Subject: Planning Consultation on: P/99/26/PL

Application ref: P/99/26/PL

Description: Change of use of land from agricultural to recreational use for the siting of 10 holiday lodges for seasonal use (1 March-30 September) with associated groundworks, landscaping, including retention of earth bund. This application affects a Public Right of Way and is in CIL Zone 5 (Zero Rated) as other development.

Location: Land north of Lagnersh House Lower Bognor Road Lagness Chichester PO20 1LW

drawing title:
Block Plan

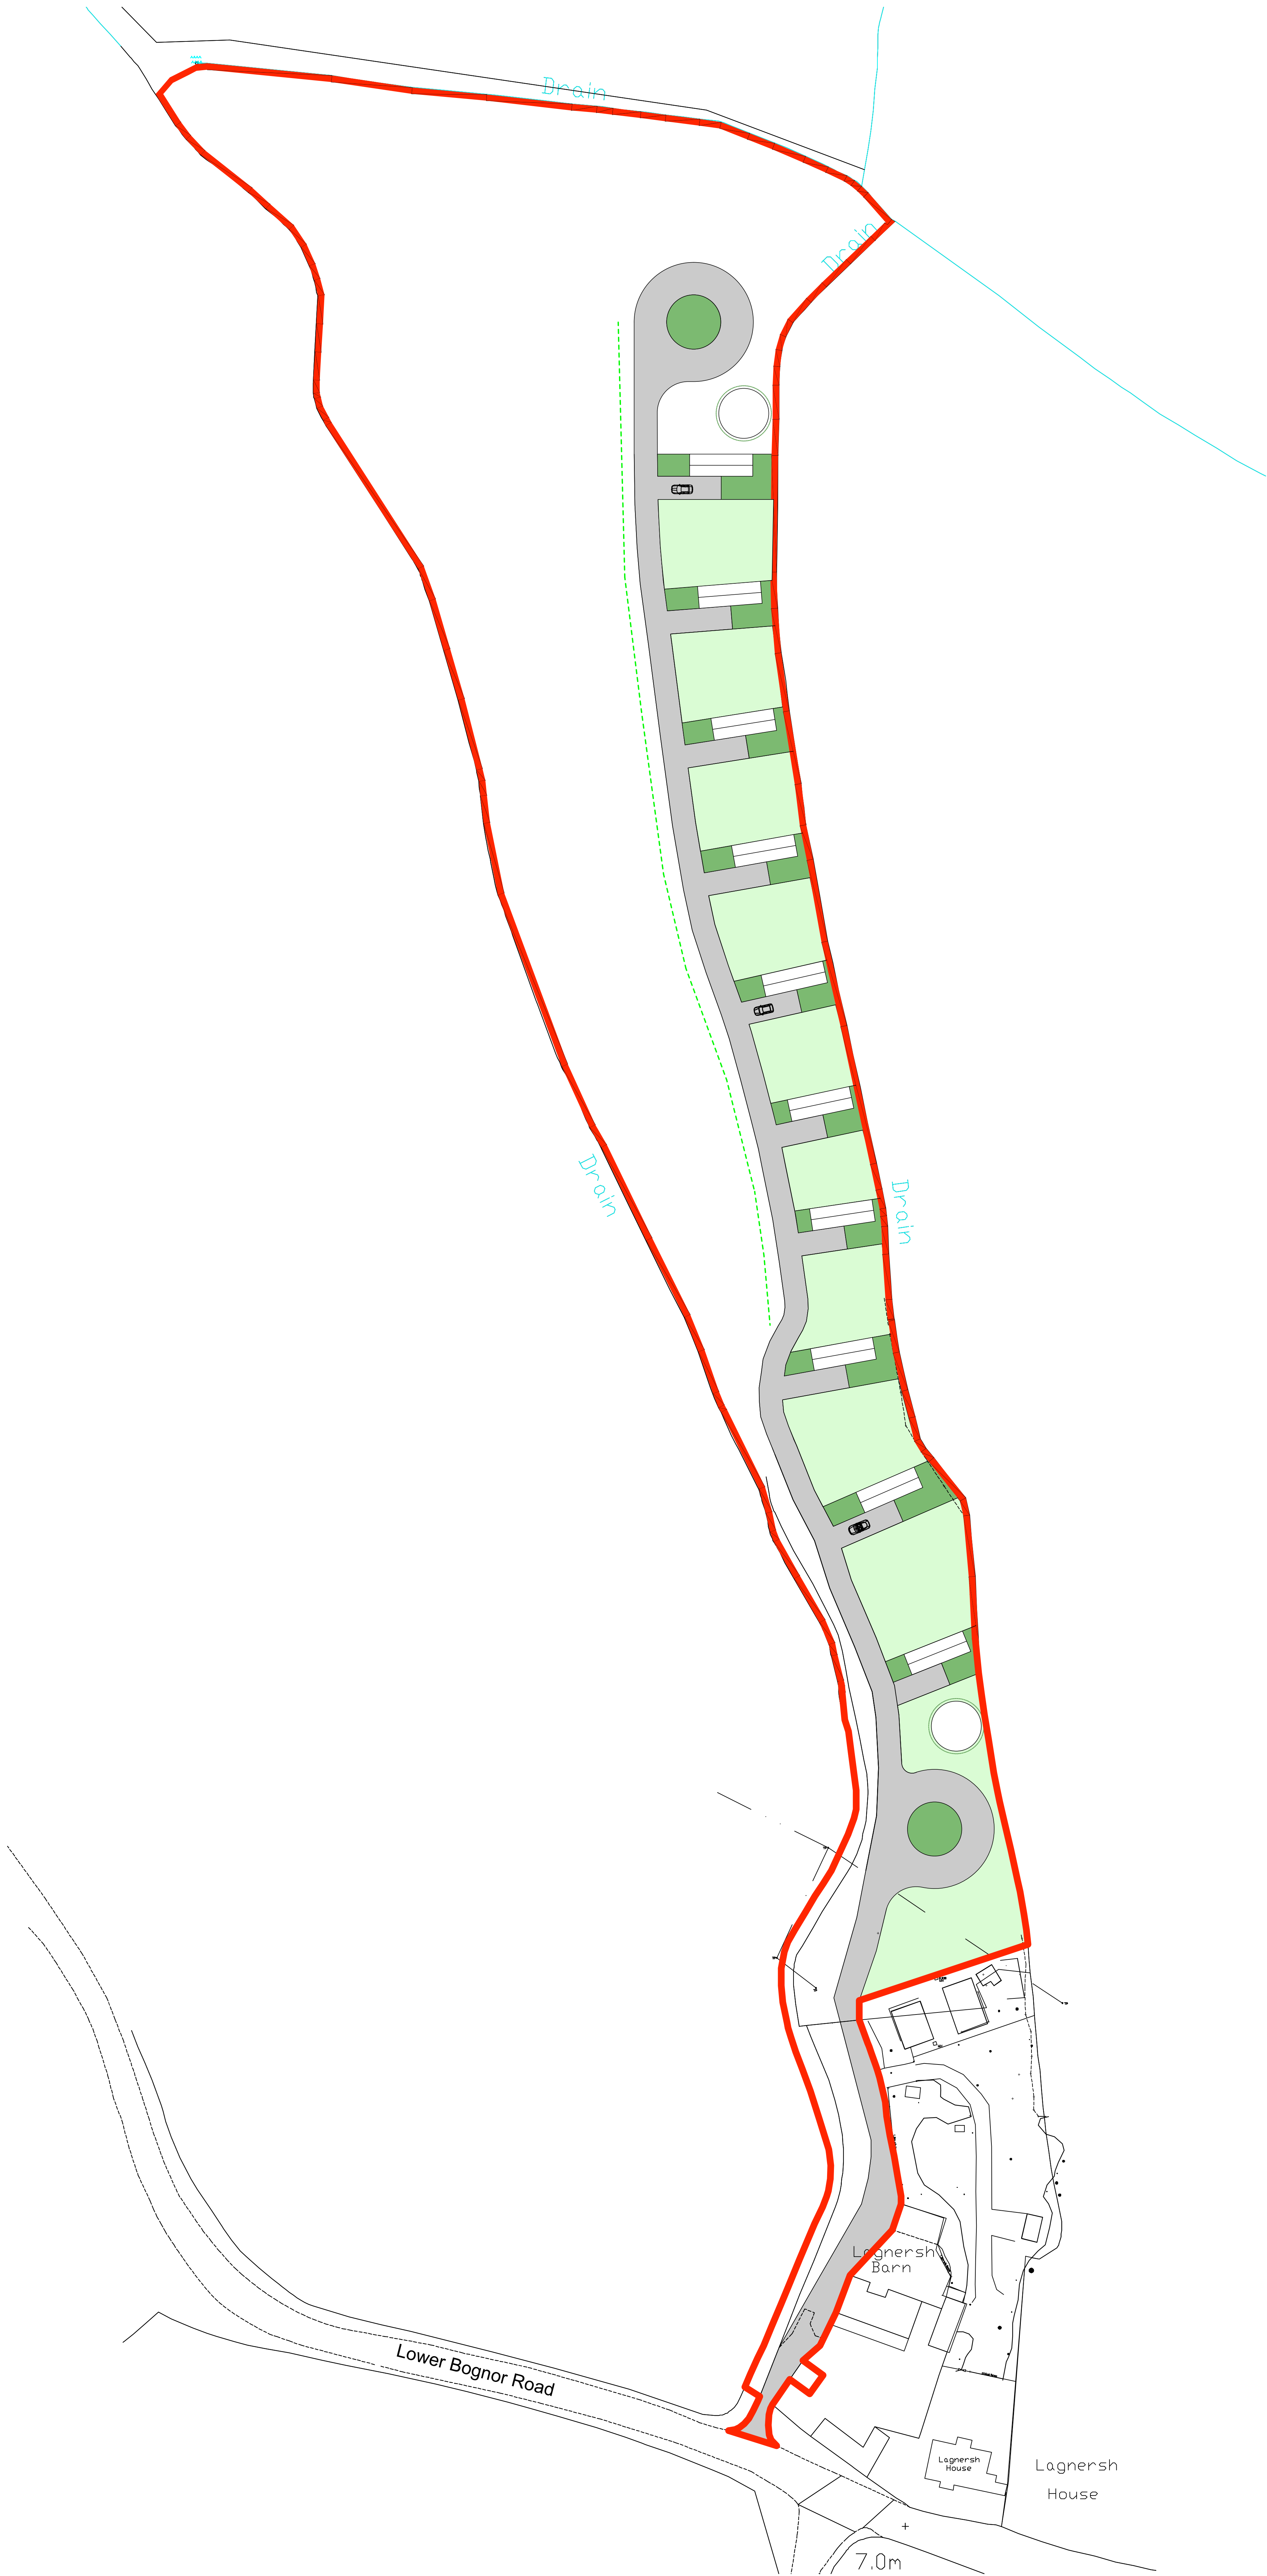
Landscape works are proposed to provide the site with vehicle access and garden/parking areas. To include new native hedging to enclosed the gardens of the proposed lodges.

The site currently forms part of the agricultural landscape and therefore the introduction of holiday lodges has potential to alter the rural character of the area. There would therefore be requirement for:

- Lodges to be sited discreetly within the landscape.
- Existing trees, hedgerows and landscape features to be retained and protected.
- The retained earth bund to serve a positive landscape and screening function.

Recommendation for the submission and approval of a detailed landscape scheme in plan form including quantities species type, planting densities and size at time of planting, to include a Native species planting schedule. Detail to be submitted to include a landscape establishment and maintenance programme. The proposals to allow for the retention and protection of all existing trees and hedgerows. The proposals to cater for the Public Right of Way protection.
